21st January 2022

East Preston Parish Council
Mr Simon Cross
Council Office
122 Sea Road
East Preston
BN16 1NN

Application No: EP/169/21/HH
Site Address: 11 Worthing Road East Preston BN16 1AT
Description of works: First floor rear extension including the installation of x2 side windows in existing gables and x3 front velux rooflights. Revision of EP/133/21/HH.

11 WORTHING ROAD, EAST PRESTON
Proposals 03 A
Oct 2021

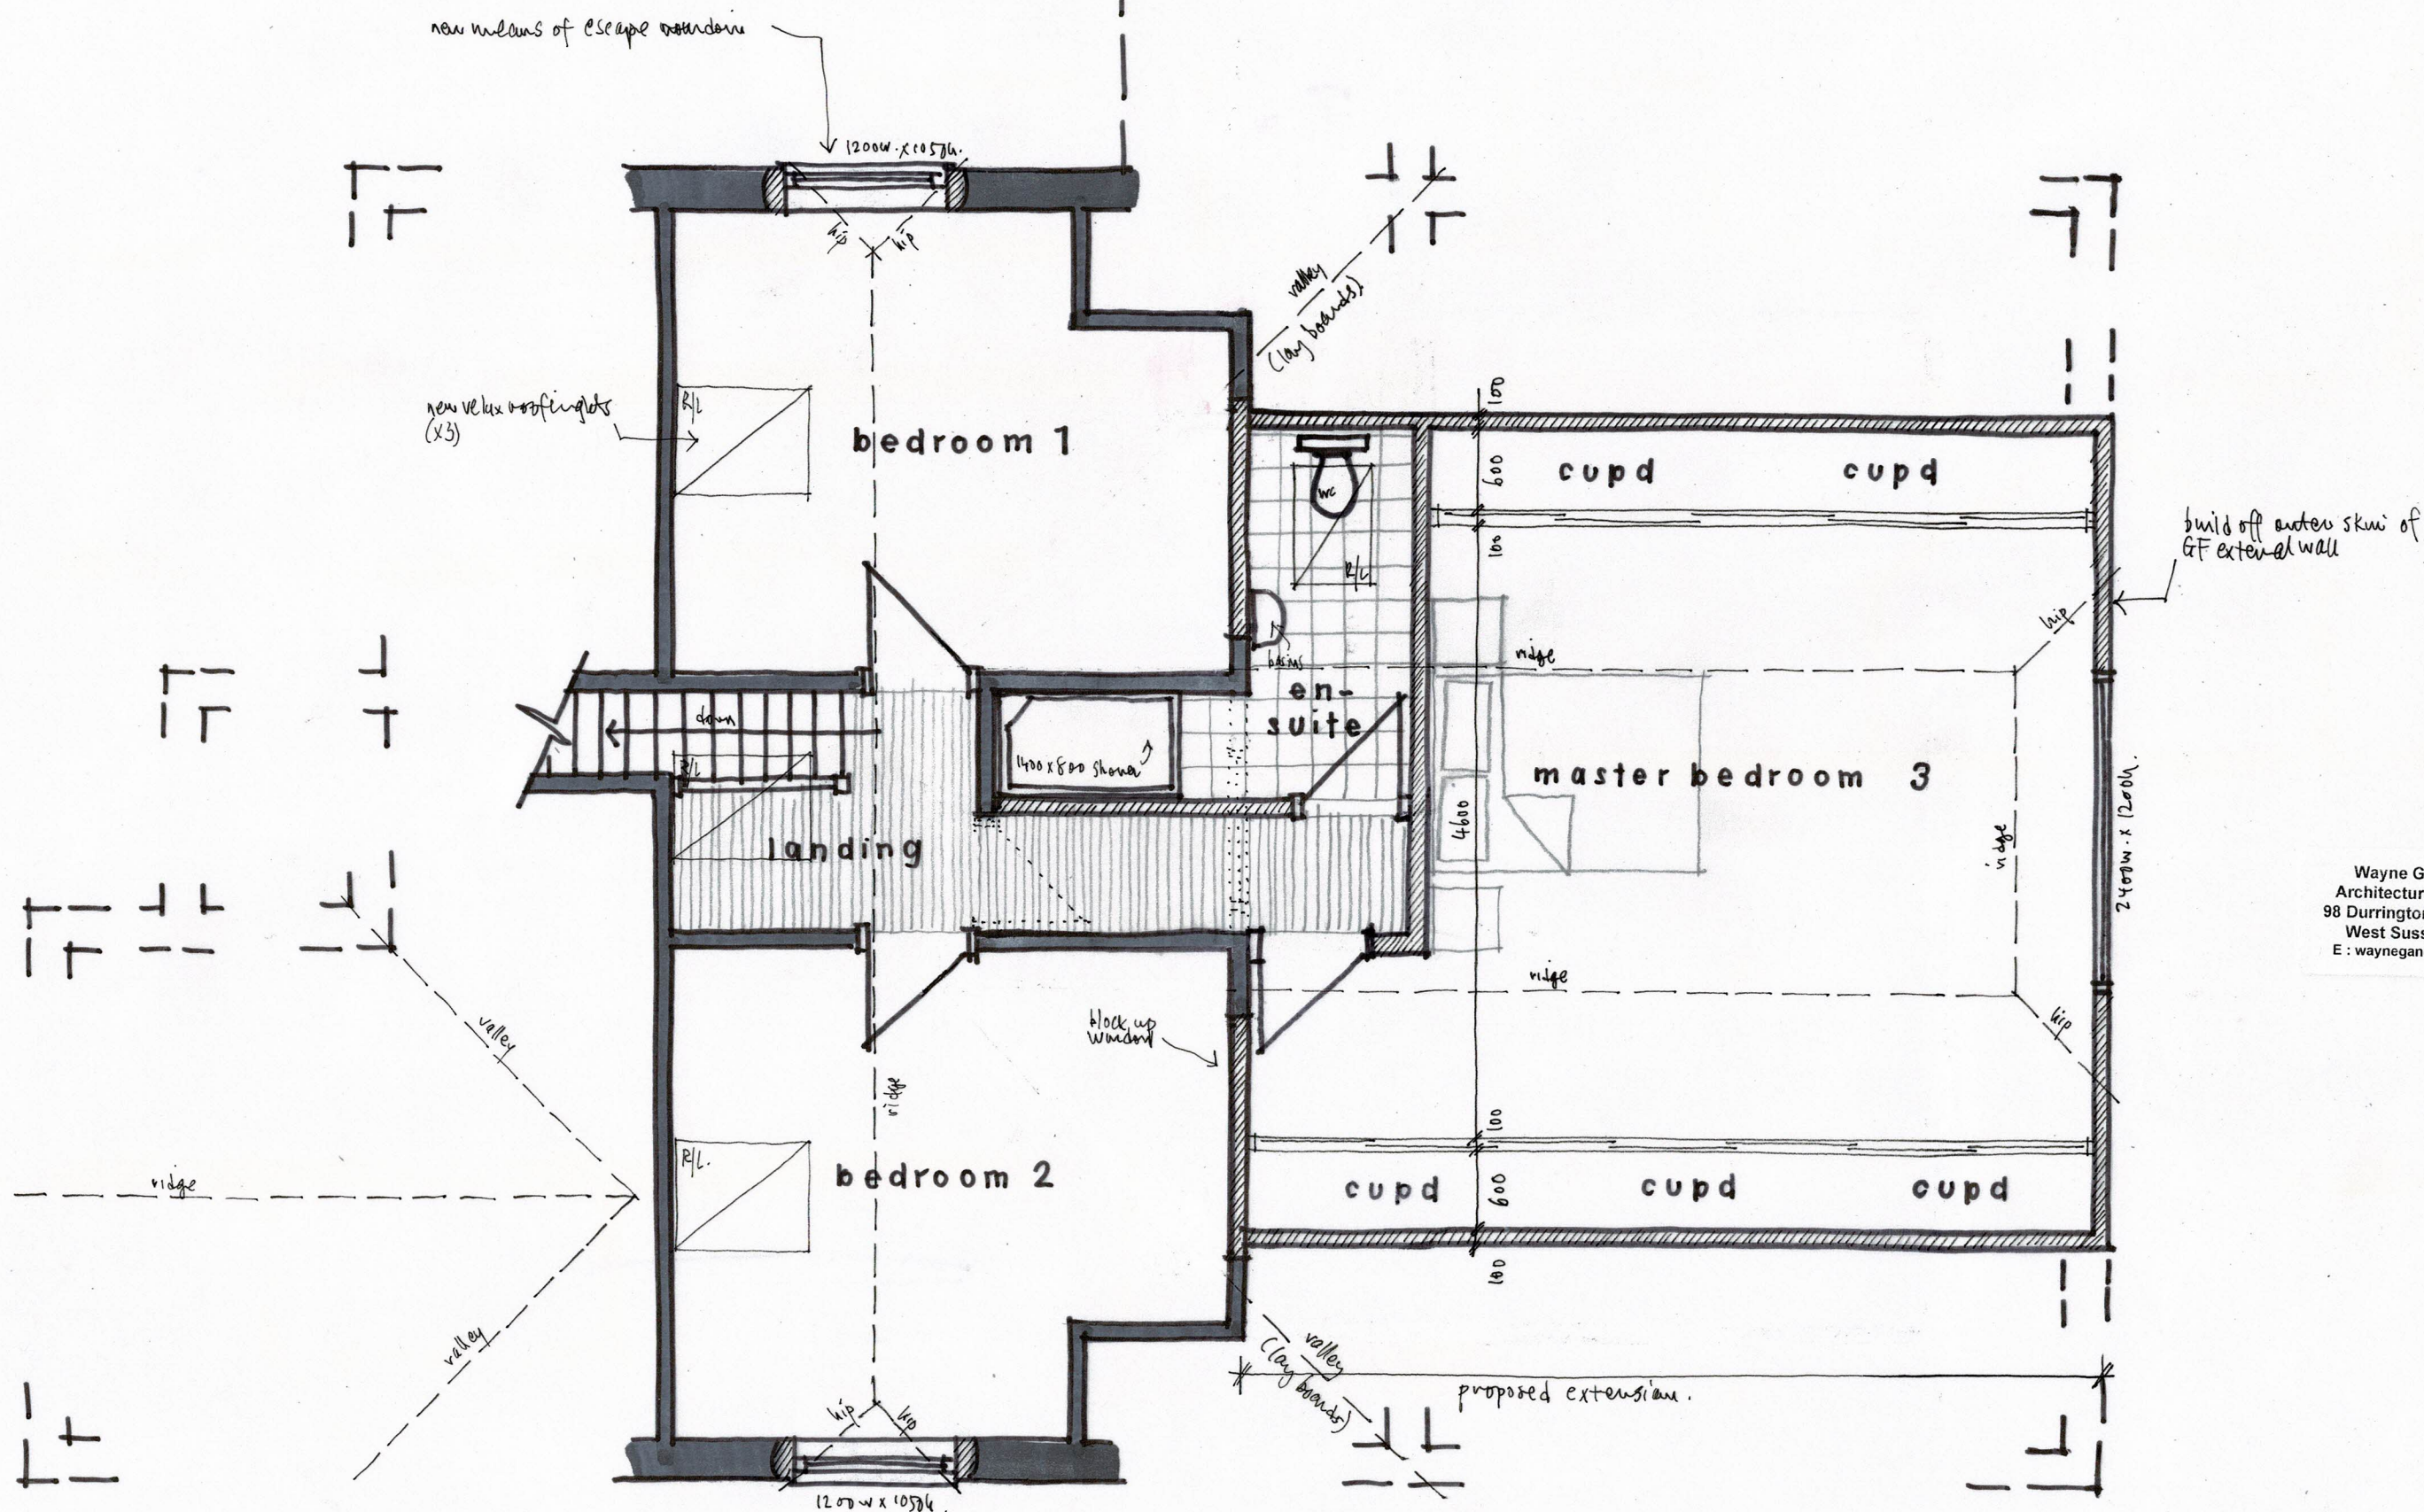
The committee agreed to object to this Application as the proposed rear extension has increased in size from Application EP/133/21/HH and therefore the objections the council raised to that Application still stand.

The committee felt the proposed development was overdevelopment, would result in a bulky and overbearing rear dormer, not especially subservient to the existing roof (contrary to paragraph 4.14 within Policy 1 of the East Preston Neighbourhood Plan) and the proposed front rooflights would not be in character with the existing streetscene. Only one of the nearby bungalows has a front dormer and none have rooflights. The revised proposal will make the proposed rear extension even more visible when walking along Worthing Road and could result in additional unbalancing between this property and its linked property.

Revisions A - new doors changed to a pitched roof
 11 WORTHING ROAD, EAST PRESTON
 Proposals 04 A
 Oct 2021

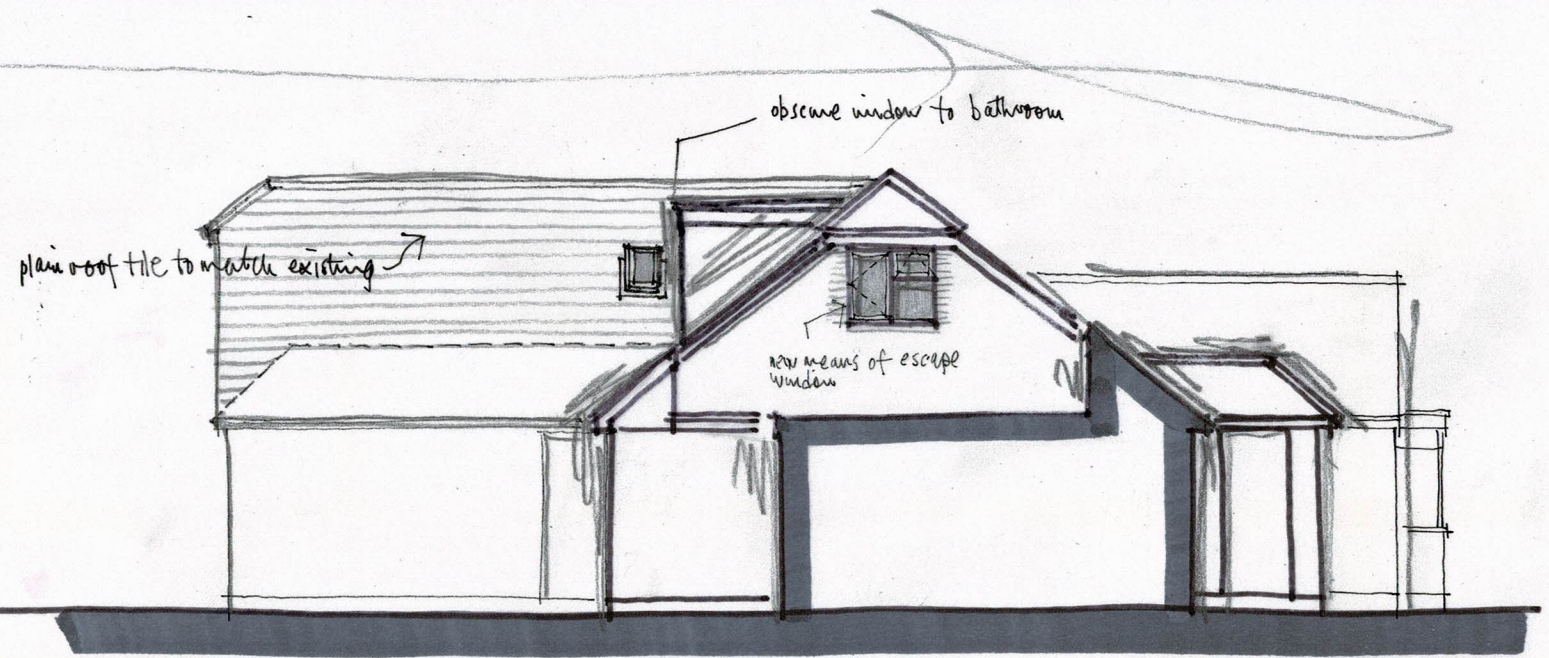
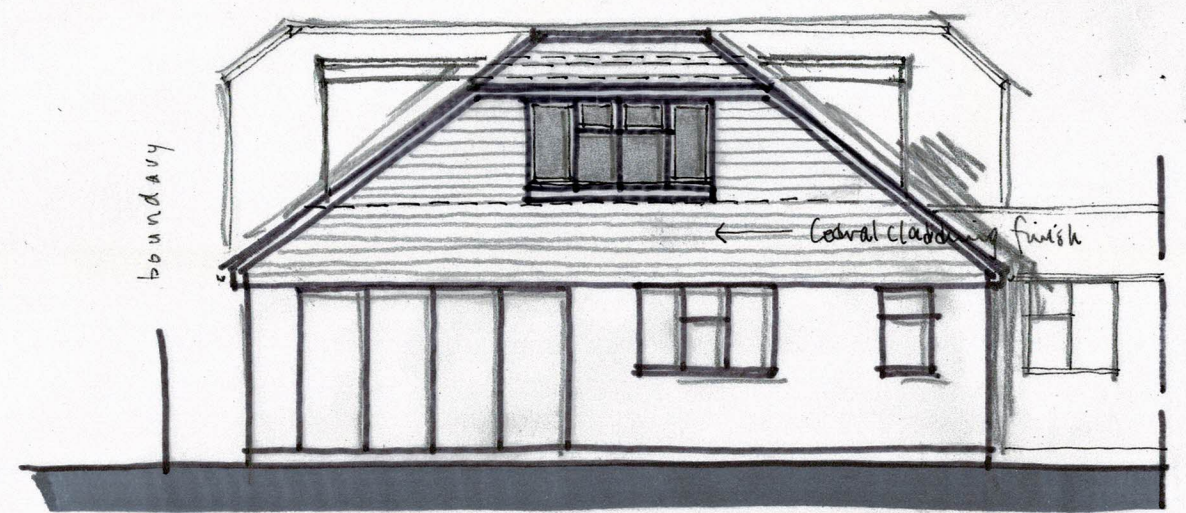
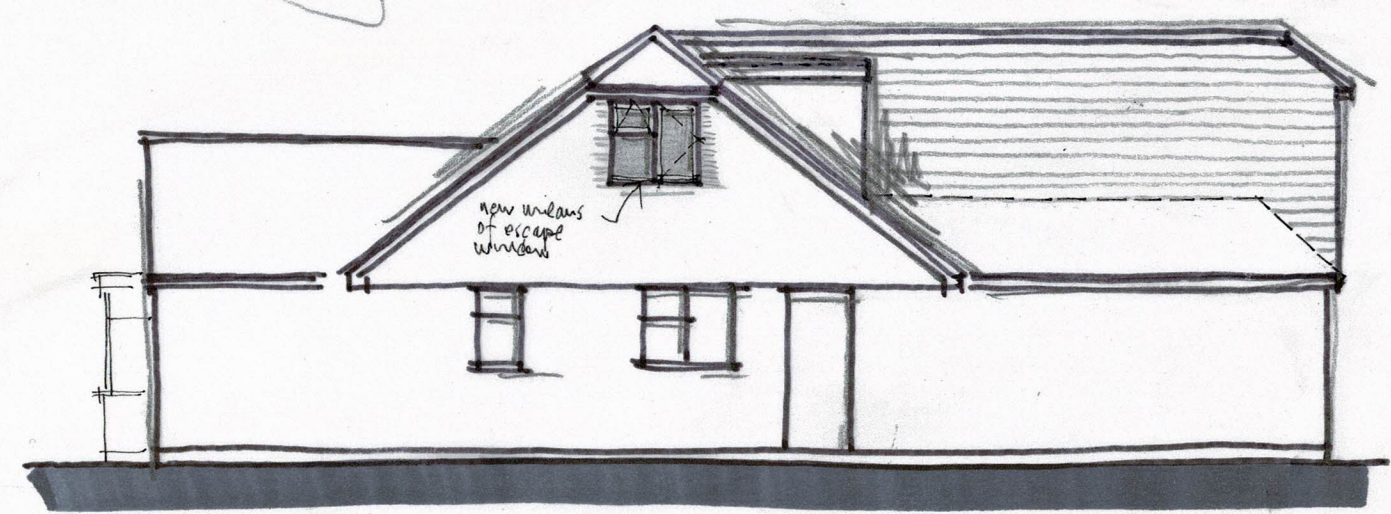
The above concerns render the proposal contrary to Policy 1 in the East Preston Neighbourhood Plan as the scale, density and massing would not reflect and enhance the architectural and historic character and scale of the surrounding buildings.
